EPC STORMWATER REVIEW COMMENTS ARE SHOWN IN ORANGE BOXES WITH BLACK TEXT

DRAWN BY: O.E. WATTS DATE: 1-20-20 DWG. NO.: 19-5348-05 SURVEYED BY: DEW, ESW, 6-26-19	APPROVED BY: PROJ. NO.: DWG.:	REVISIONS 7-28-20 REVISED PER COUNTY REVIEW COMMENTS DEW	OLIVER E. WATTS CONSULTING ENGINEER COLORADO SPRINGS	PROJECT 10634 & 10658 MALTESE POINT LOTS 2 & 3, ROLLING THUNDER BUSINESS PARK EL PASO COUNTY	SHEET NAME GRADING AND EROSION CONTROL PLAN	SHEET NO. 1 OF 2
---	-------------------------------------	--	--	---	---	---------------------

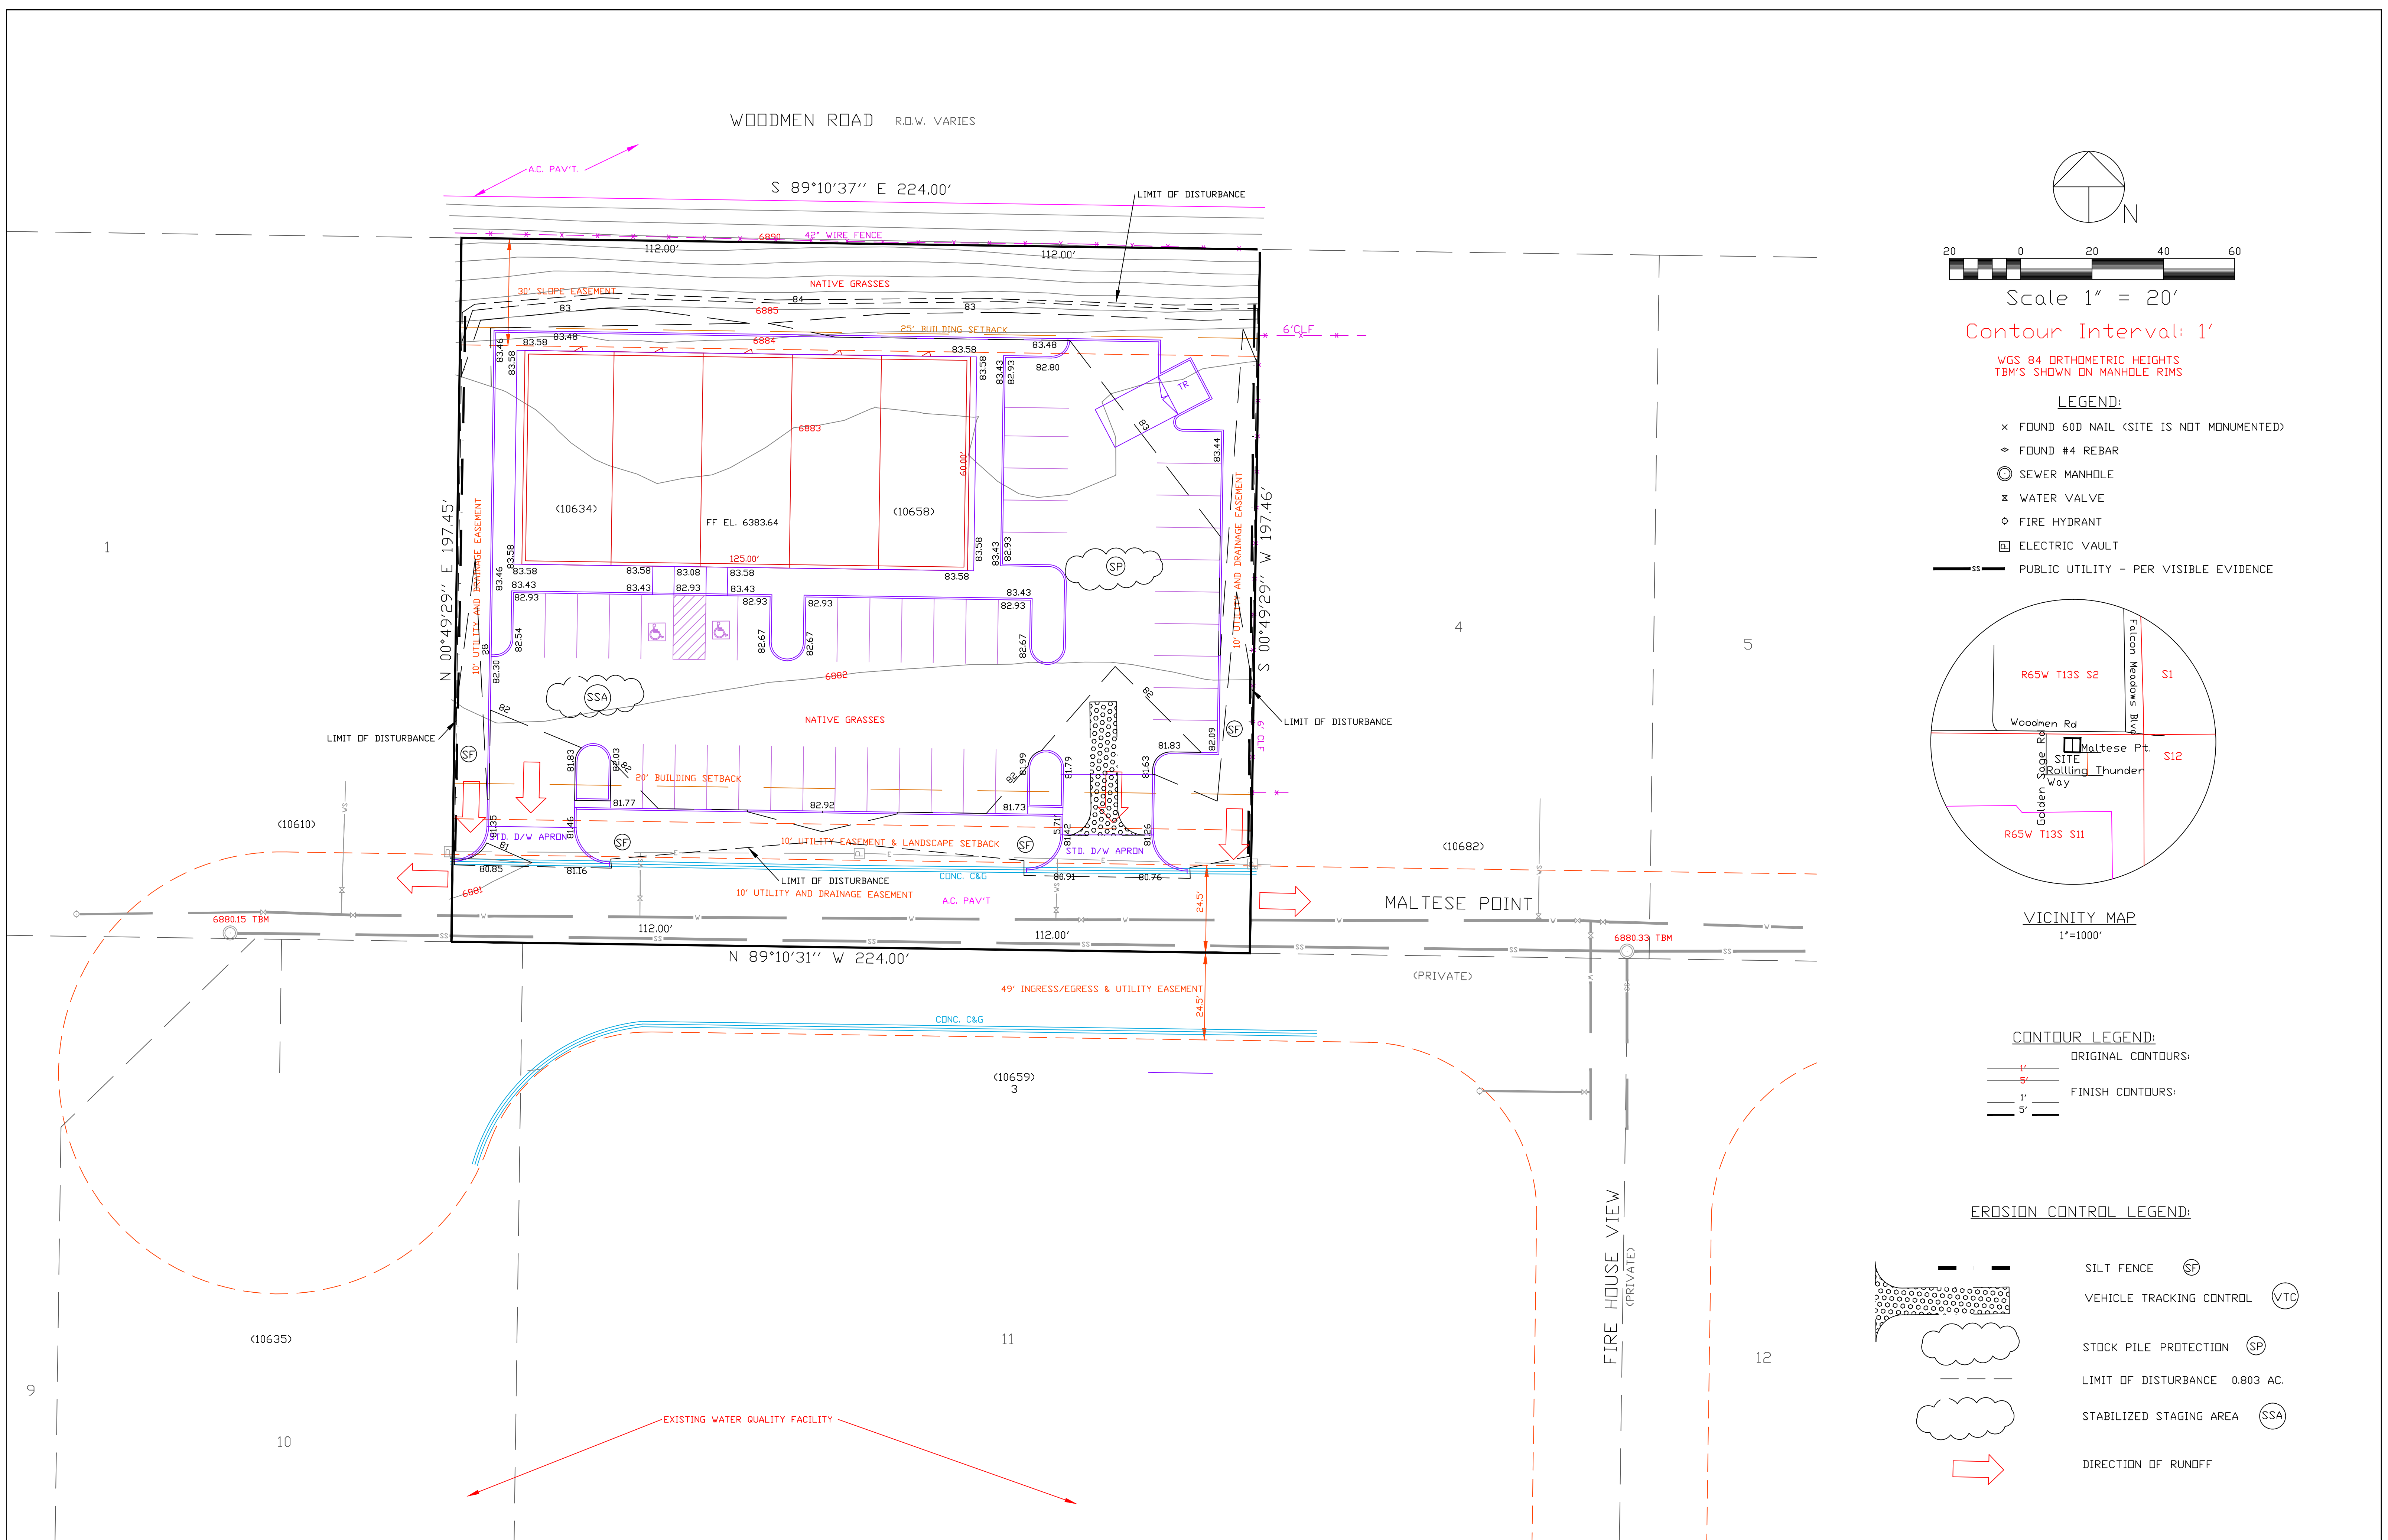
Review 1 comment: Please label the proposed curb and gutter throughout the site and provide a detail.
Review 2: Unresolved.
Review 3: Unresolved. Please provide labels on the plan so that it is clear where a curb is proposed.

Adjust line type to match legend
LIMIT OF CUT
LIMIT OF DISTURBANCE

Label this line type.
Unresolved.

Label adjacent properties
Unresolved.

show line for silt fence
Unresolved.

which side of the line is cut?
which side of the line is fill?

STD. COUNTY DRIVEWAY
SEE DWG. NO.'S SD_2-23,
& SD_2-24
barricade entrance to prevent traffic from entering/exiting the site without using the VTC
Unresolved.

There is no pond here. Show the location of the pond. This can be shown in a separate view port or separate page.
Unresolved.

Show Property and Construction Boundaries
Unresolved.

Show areas of temporary and permanent seeding
Label all proposed temporary construction control measures by phase of implementation (initial, interim, final).
Unresolved.
